SSD 10477 – Stage 3 Facilities Sydney Business Park, Marsden Park

ATTACHMENT A

Review of the engineering plans by Orion Consulting for stage 3 Sydney Business park, Project No. 20-0127, Set 02, Rev. A, Dwg. No. 000 to 602, dated 31.07.20 raised the following issues:

ENGINEERING PLAN SHEET 02 OF 05				
Project No.	Set No.	Milestone	Plan	Revision
20-0127	02	DA	201	A

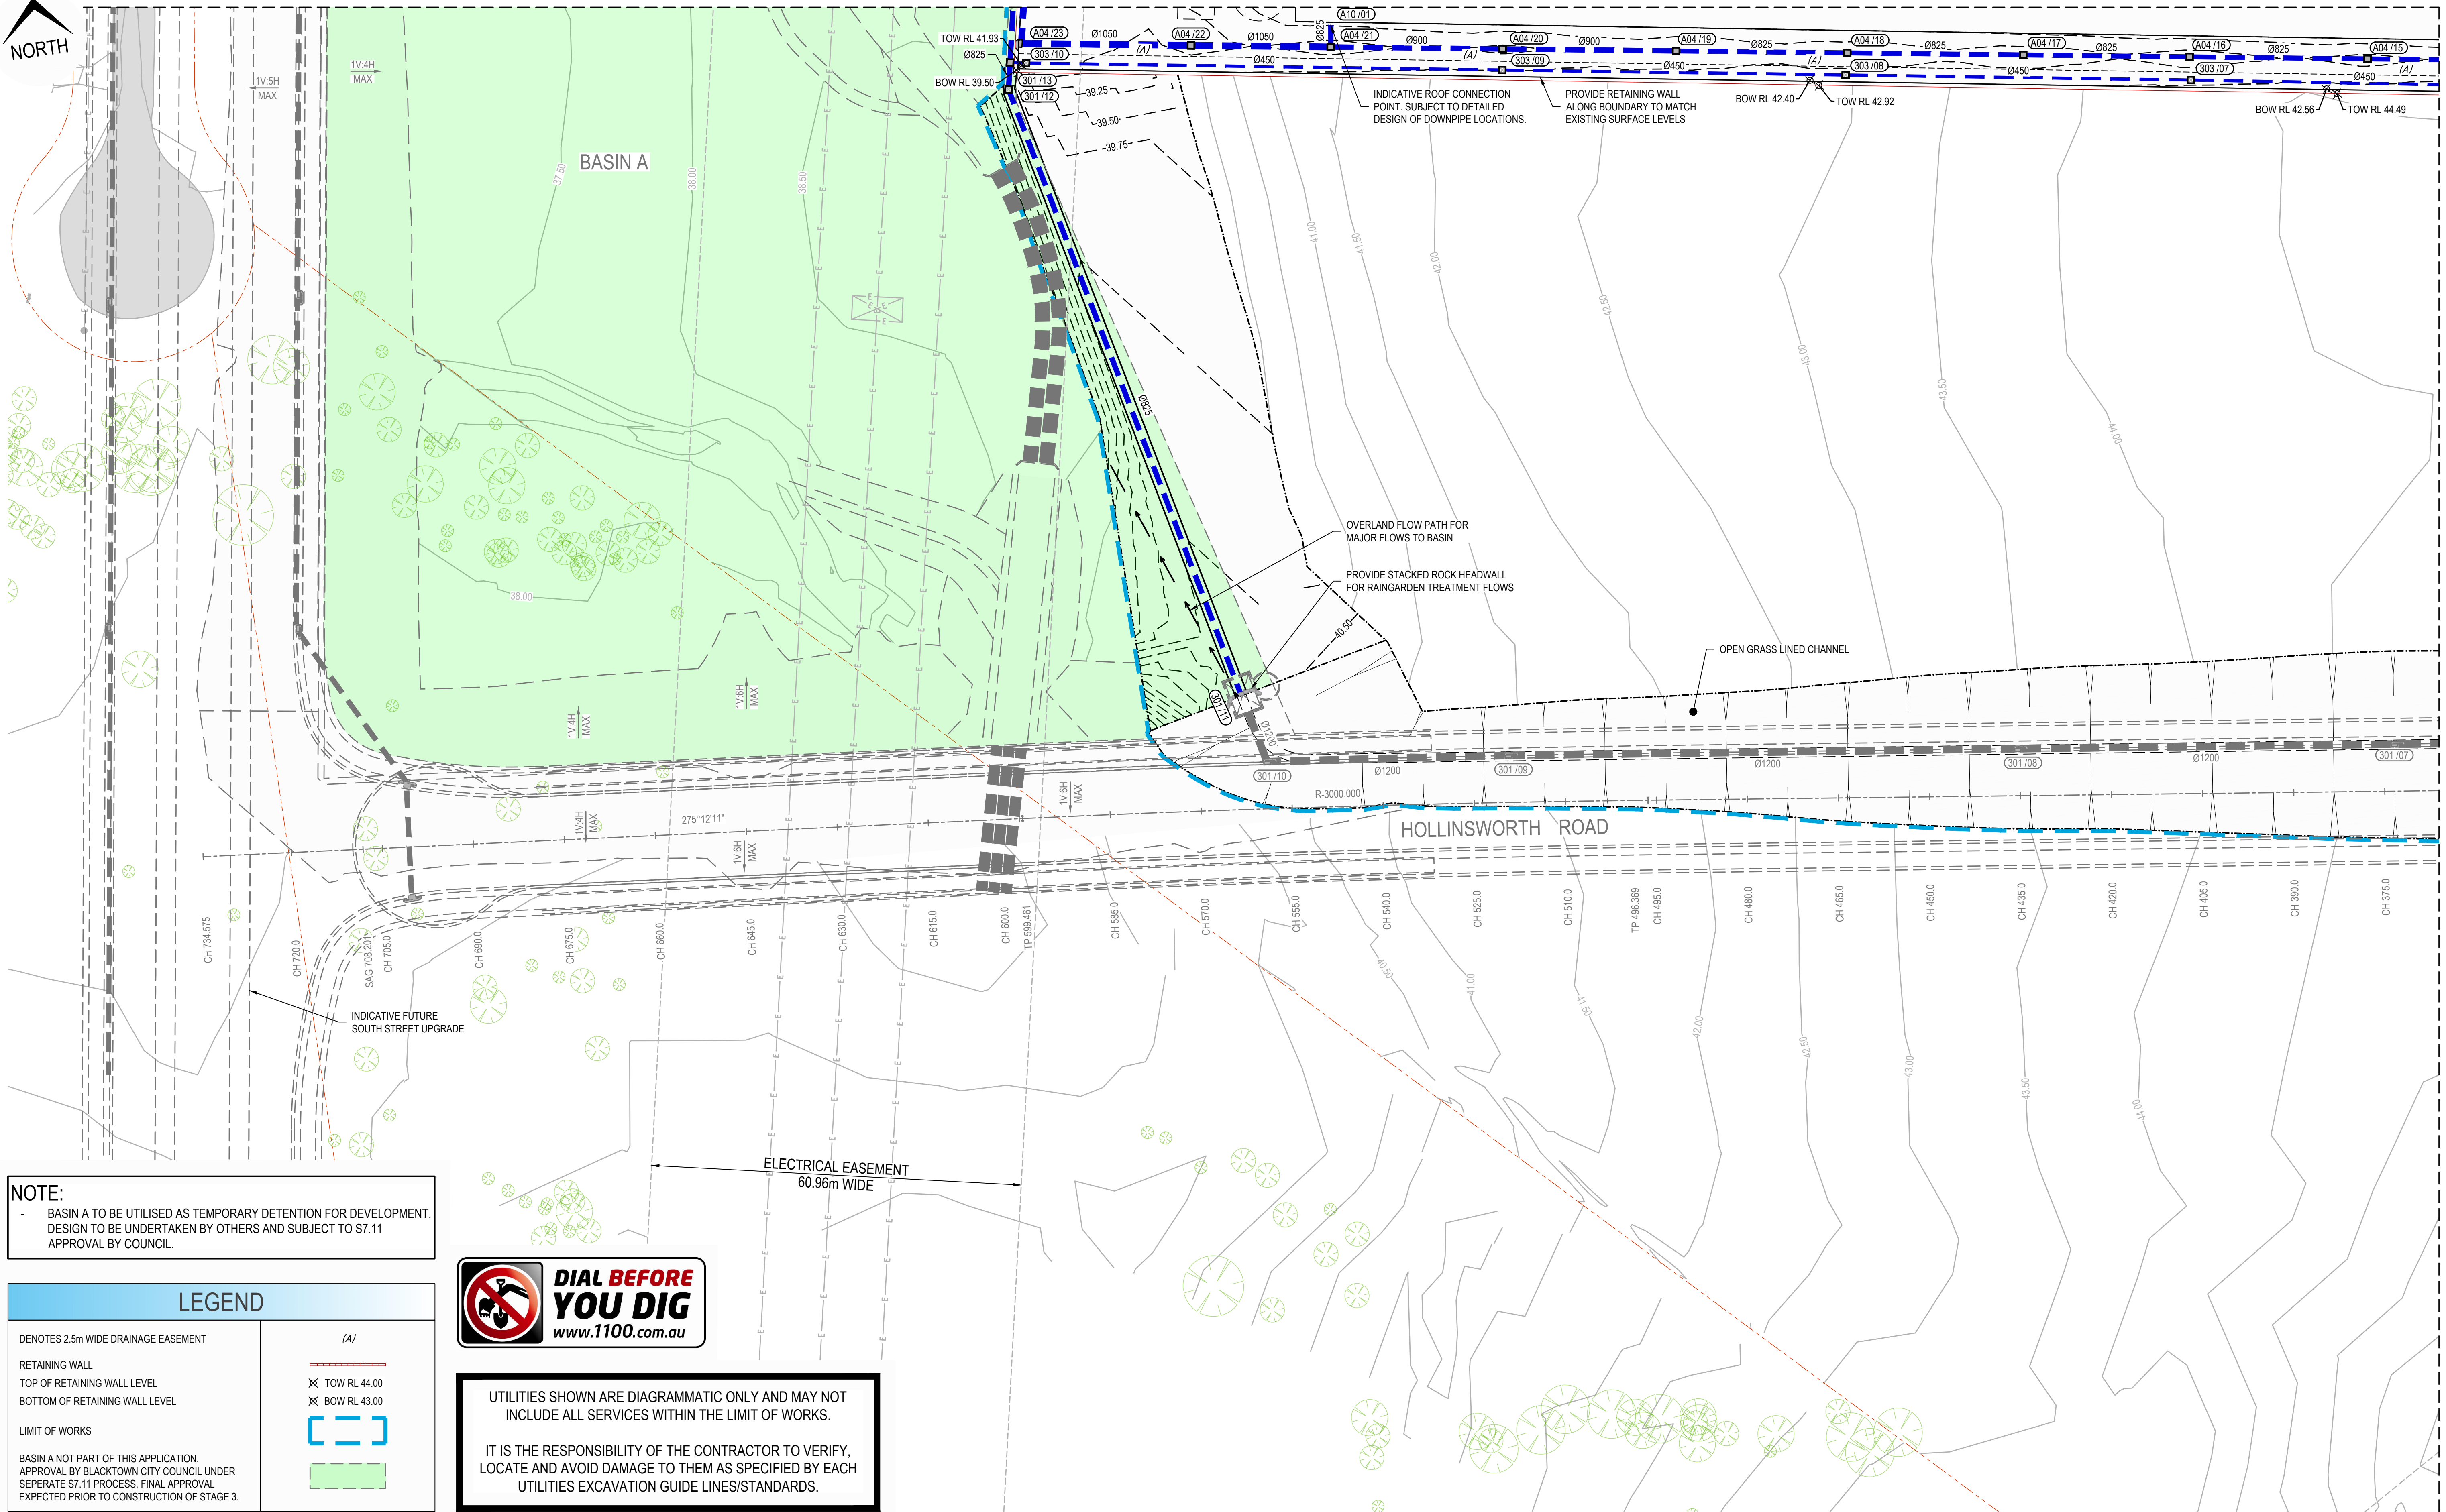
27. Dwg. 201 (A) and 203 (A), Provide a name to indicate the existing portion of Hollinsworth road and future Hollinsworth road.
28. Dwg. 200 (A) to 204 (A), there are several downpipes running through rainwater tanks. Fix this drafting error.

33. Dwg. 201 (A) to 203 (A): Provide top and bottom spot levels for the proposed temporary open grass lined channel. State that this is temporary.
34. Clearly provide notes for the future and temporary infrastructure on all plans.

36. Dwg. 201 (A): Provide temporary suitable scour protection at the turn of the open grass lined channel just before the future regional GPT.
37. Revise all models, reports and plans to reflect the above comments.

38. Provide a clear roof/awning outline.
39. Headwall 301/11 on Dwg. 201 should only cater for the 3 months flows to the ultimate bioretention. Resize this pipe to suit the 3months flows. Any flows in excess of the 3month flows must be conveyed to the ultimate basin once constructed.

Title: ENGINEERING PLAN SHEET 03 OF 5				
Project No. 20-0127	Set No. 02	Milestone DA	Plan 202	Revision A

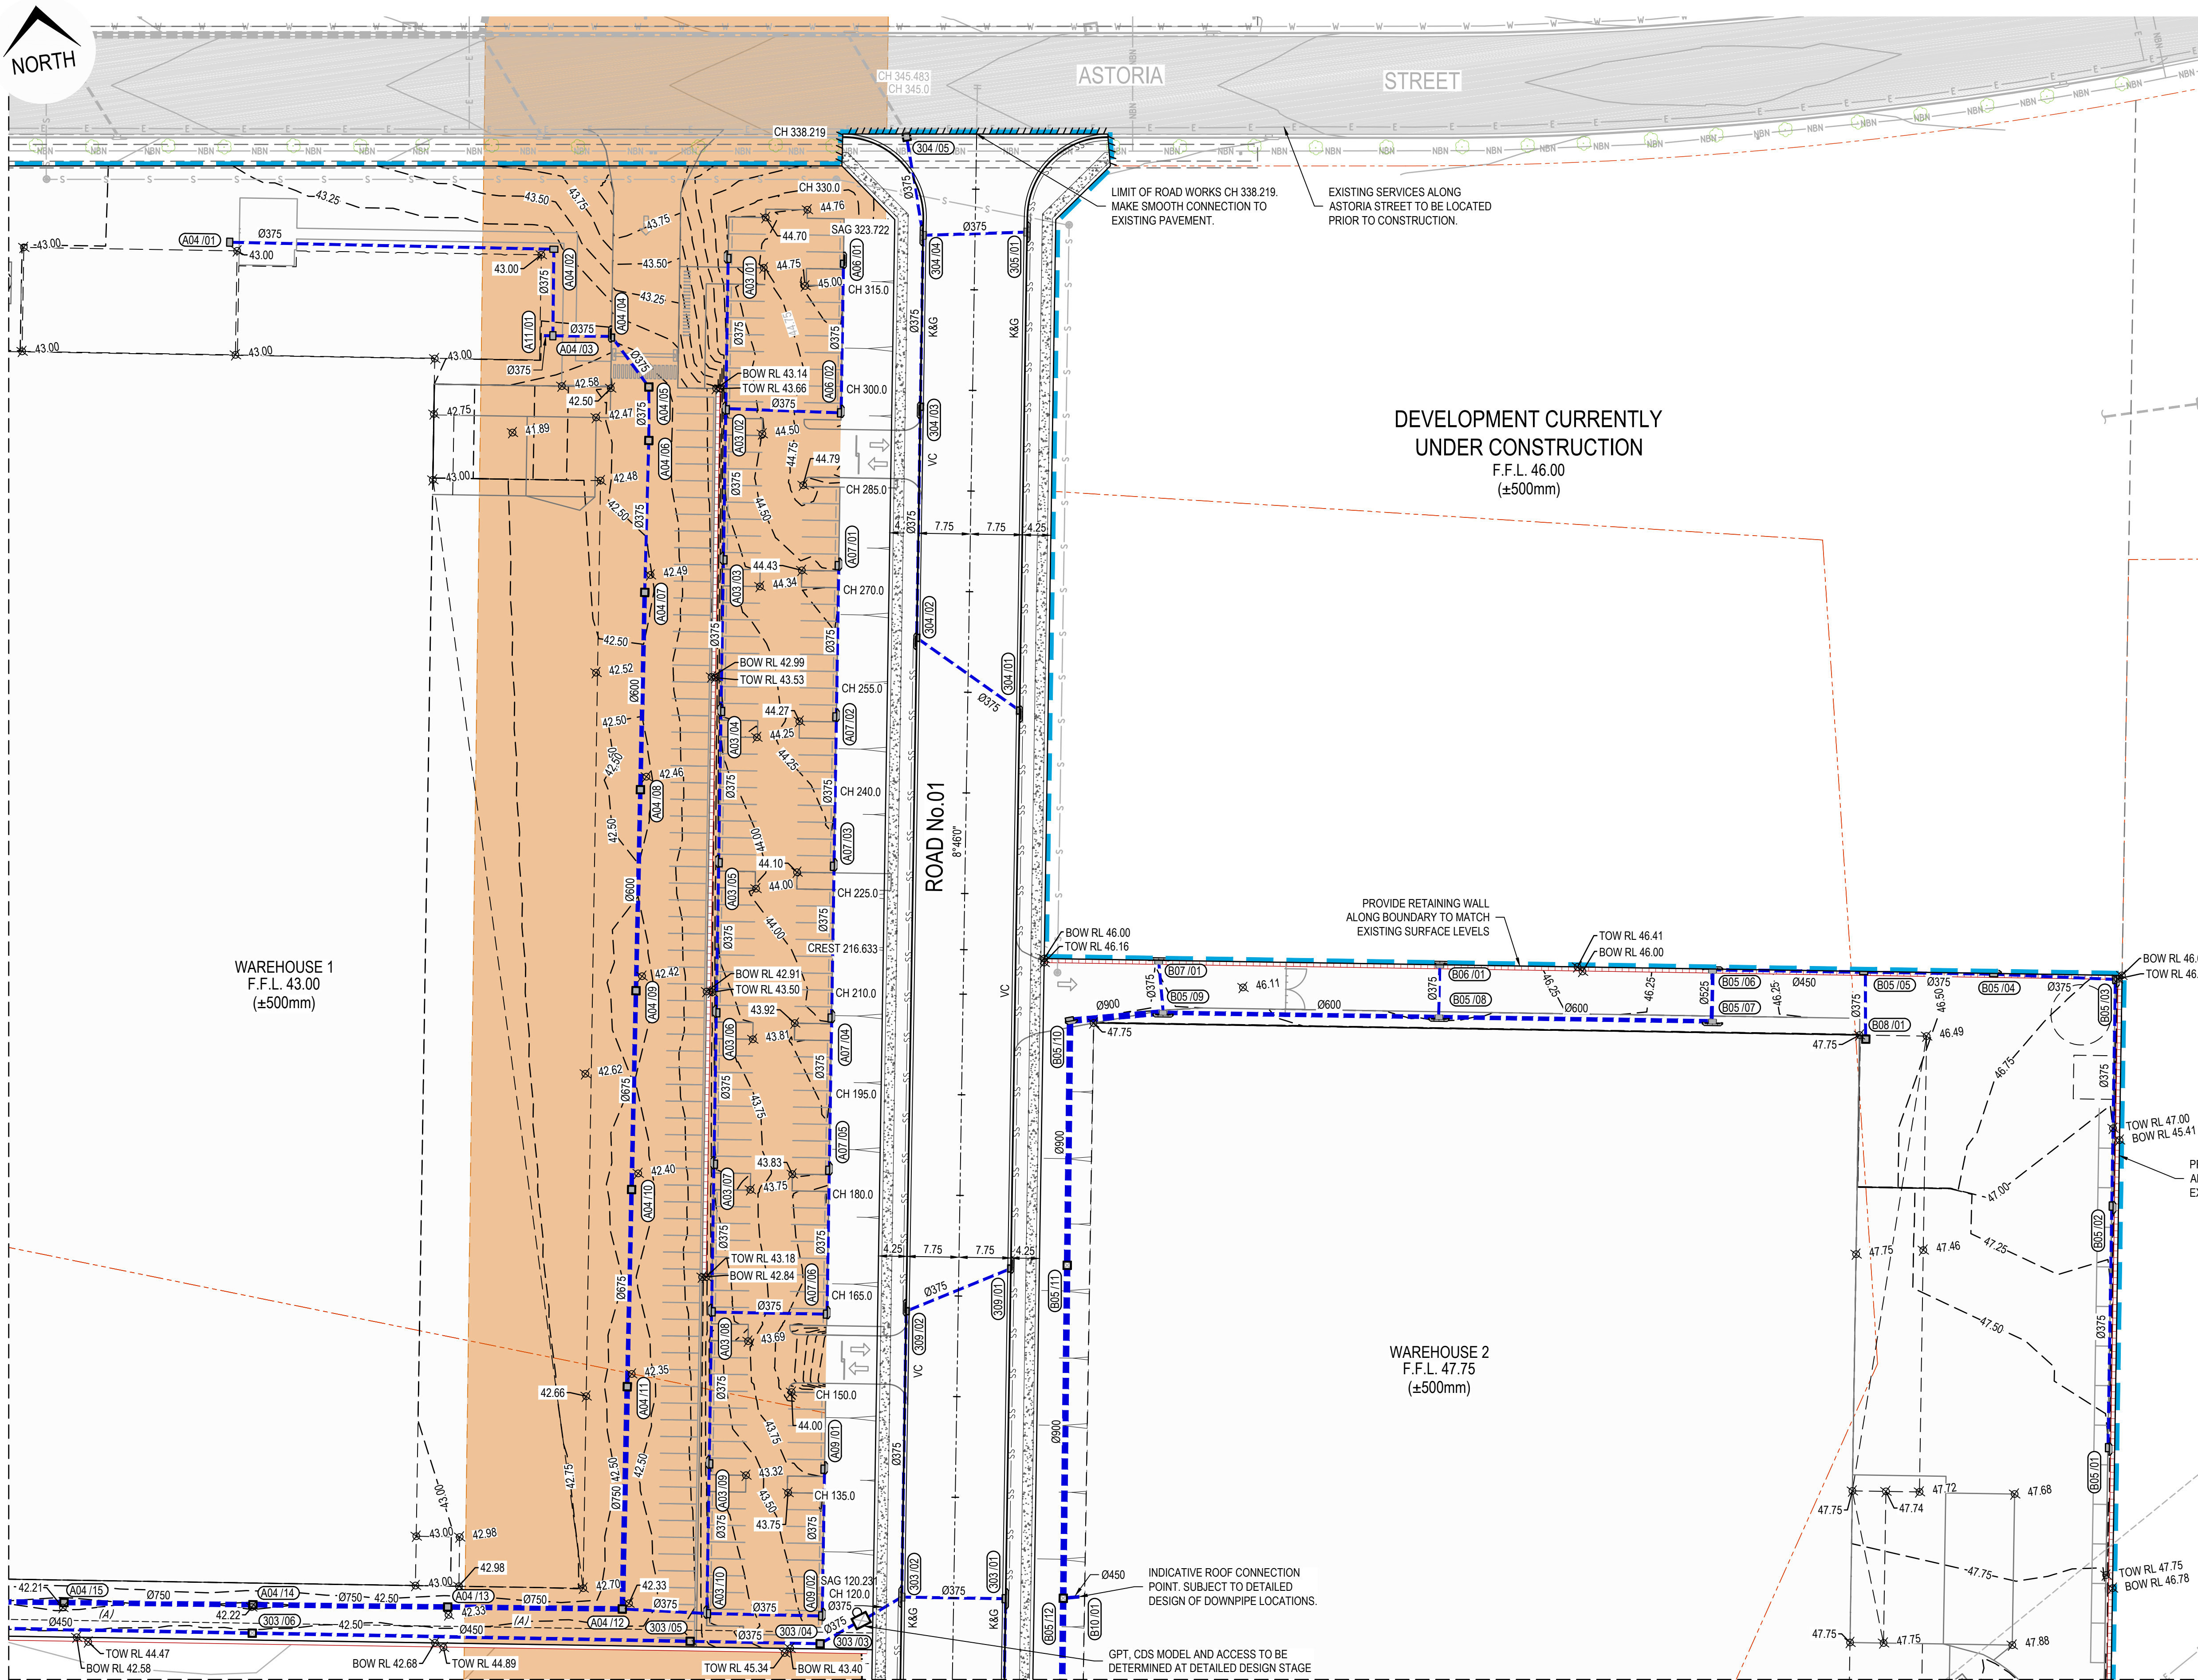
7. Dwg. 202 (A) to 203 (A), the landscaped area to the west of warehouse 2 is shown to be treated. However, this battered landscaped area is bypassing treatment. Either consider this as bypass or provide a swale at batter toe to collect this flow. Design for the 20-year storm at minimum. Drainage line from B05/10 to B05/13 is to be moved adjacent to the toe of batter to assist in collecting the swale flows. Provide calculations and cross sections of the swale.
